To: **An Coimisiún Pleanála**

Re: **Observations on the Proposed Lissinagroagh (Dough Mountain) Wind Farm Development.**

Applicant: **FuturEnergy**

Case Reference: **PAX12.324290**

Figure 8 – Mapped landslide extents (Source: GSI National Landslide Susceptibility Mapping, 2021)

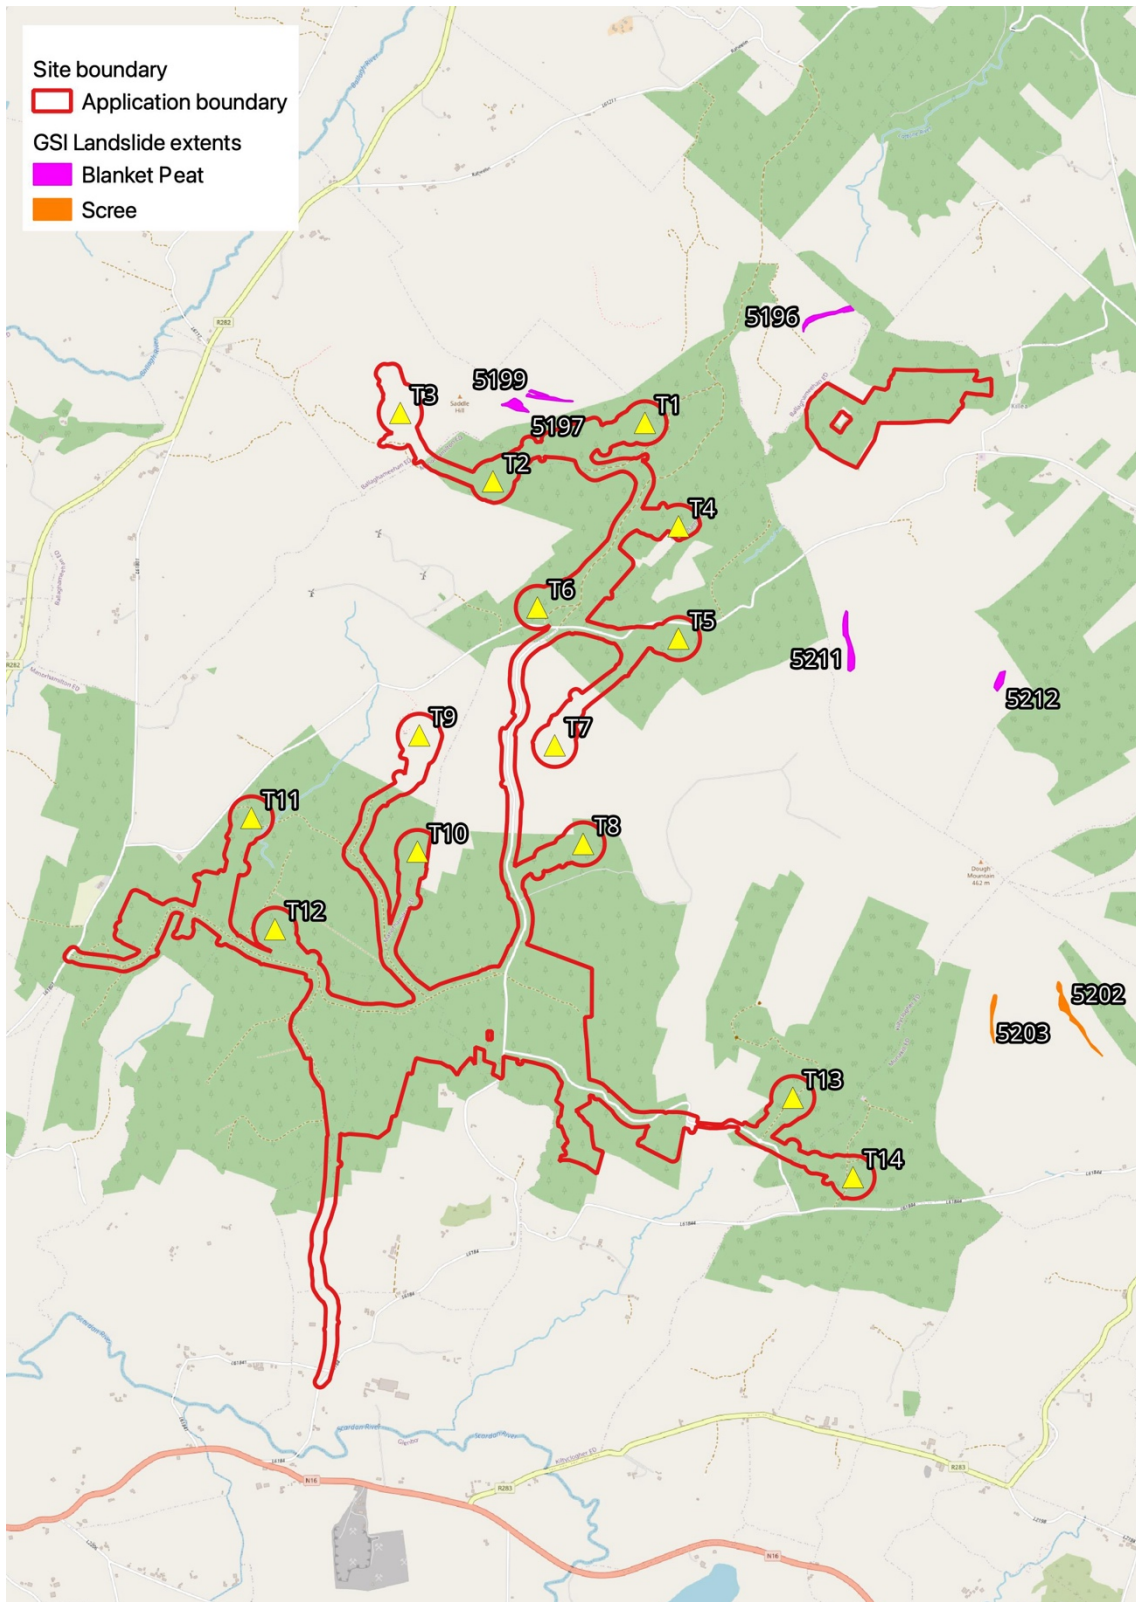
Interestingly, the Tobin study reports that “there is no recorded history of landslides within the farm site boundary or surrounding area (GSI,2025),”⁶ while Ciaran Reilly & Associates provide maps showing five peat slides and two scree landslides from the GSI National Susceptibility Mapping 2021⁷ and saying as much in the text. Some of these peat slides appear to be within a few hundred metres of these turbines, i.e., T1, T2 and T3. (T3 also overlooks a high landslide risk area on the northwest flank of Shasmore according to EIAR maps.) The GSI Irish Landslides Database also confirms five shallow peat slides and two scree slides have been recorded in the vicinity of the site. Leitrim County Council are aware of, or in possession of documentation, of over 55 previous landslides/land slippage in the North Leitrim region.

Figure 9 - Landslide susceptibility (GSI, 2021)

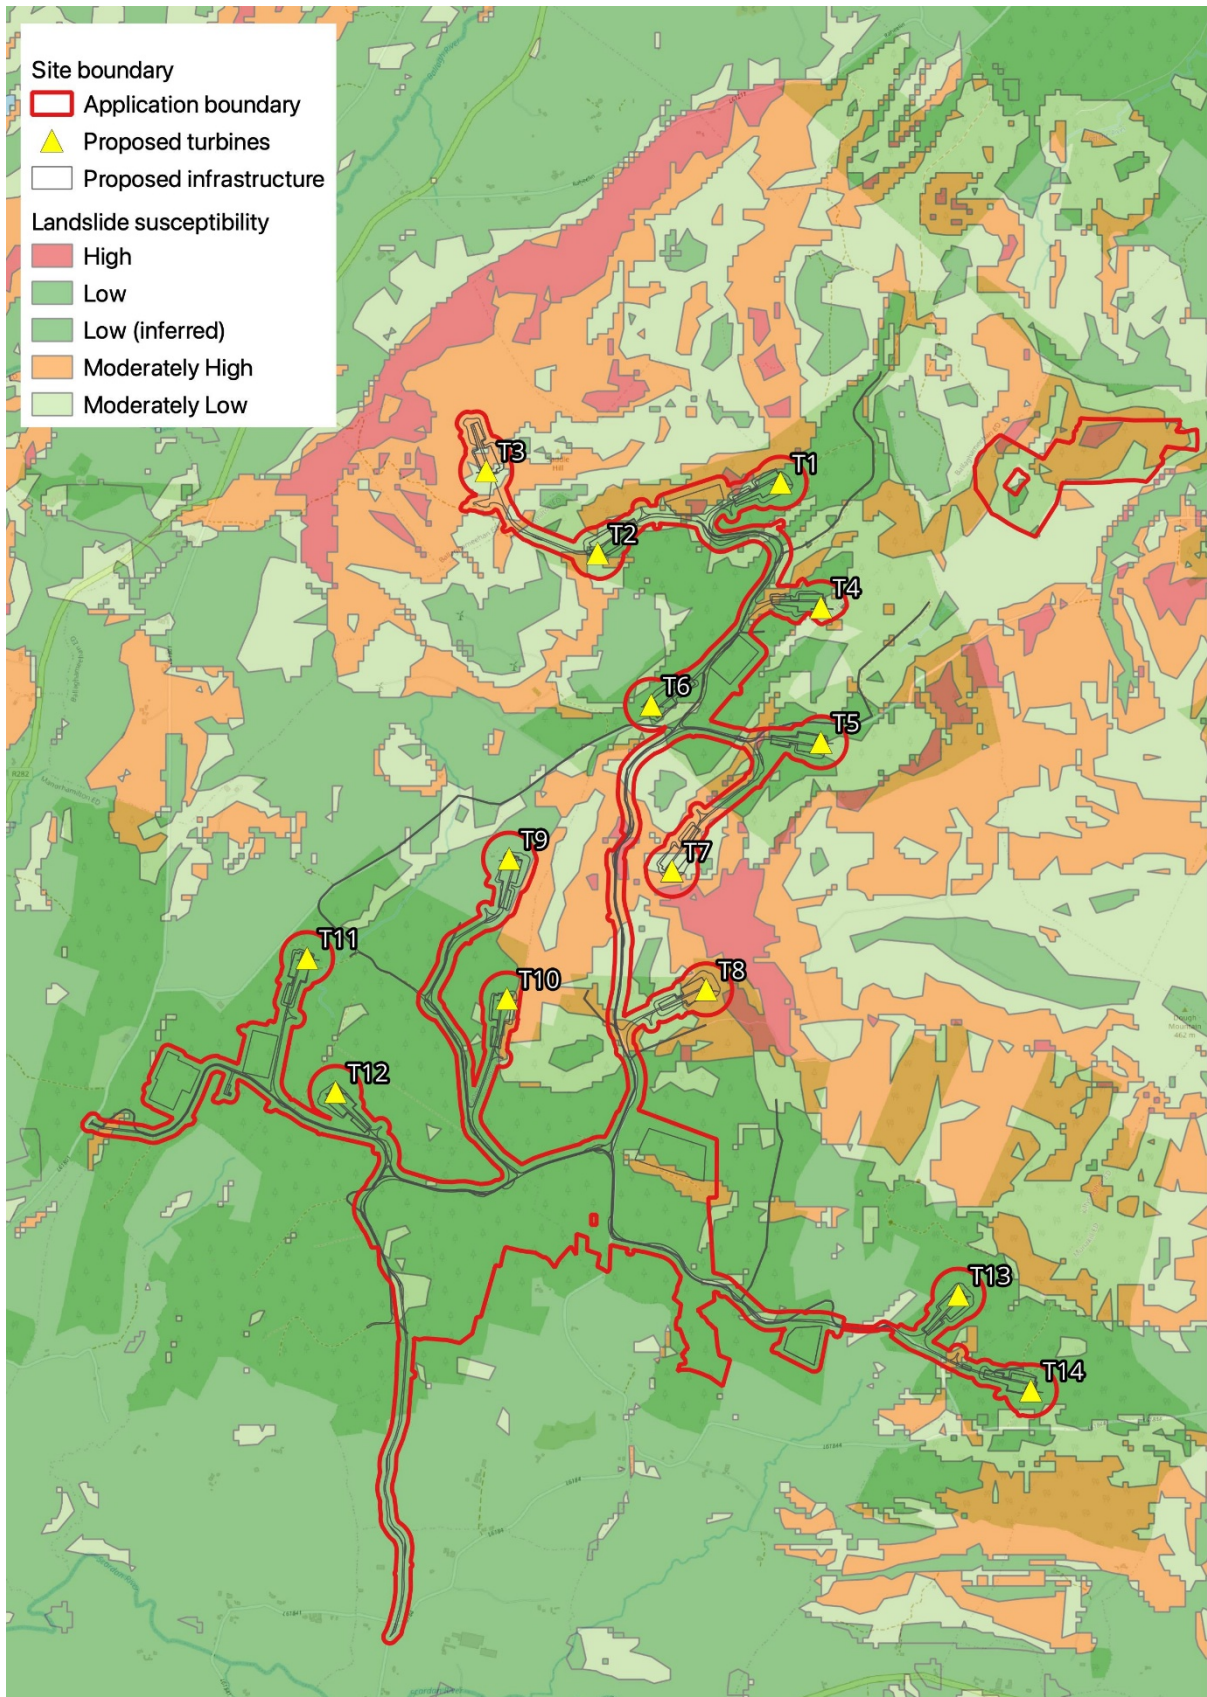
Perhaps the most concerning threat to the mountain and its surrounding Special Areas of Conservation, i.e., Lough Melvin SAC in particular, is the precarious siting of turbines, particularly T1-T7, high up in the northwest of the site. This is an area where deep upland blanket bog and peat soils are clustered on the mountain. Because these turbines are positioned on slopes with deep peat layers they sit closet to the regulatory edge. Estimates of stability in these regions indicate they are very close to any acceptable safety margin despite all turbines and substation footprints being designated with a ‘Low’ hazard index, determined using a recognised methodology,⁴ with the exception of turbines T3, T4, T5, T7 and T8. However, in the individual Tables⁵ summarising site properties T1 and Borrow Pit 1 are in the ‘High’ landslide susceptibility

category with a further eight sites in the ‘Moderately High’ class. Where a chapter and its own supporting evidence diverge on a matter as fundamental as the susceptibility class of the ground beneath a turbine, is reason enough to treat any conclusion with caution.
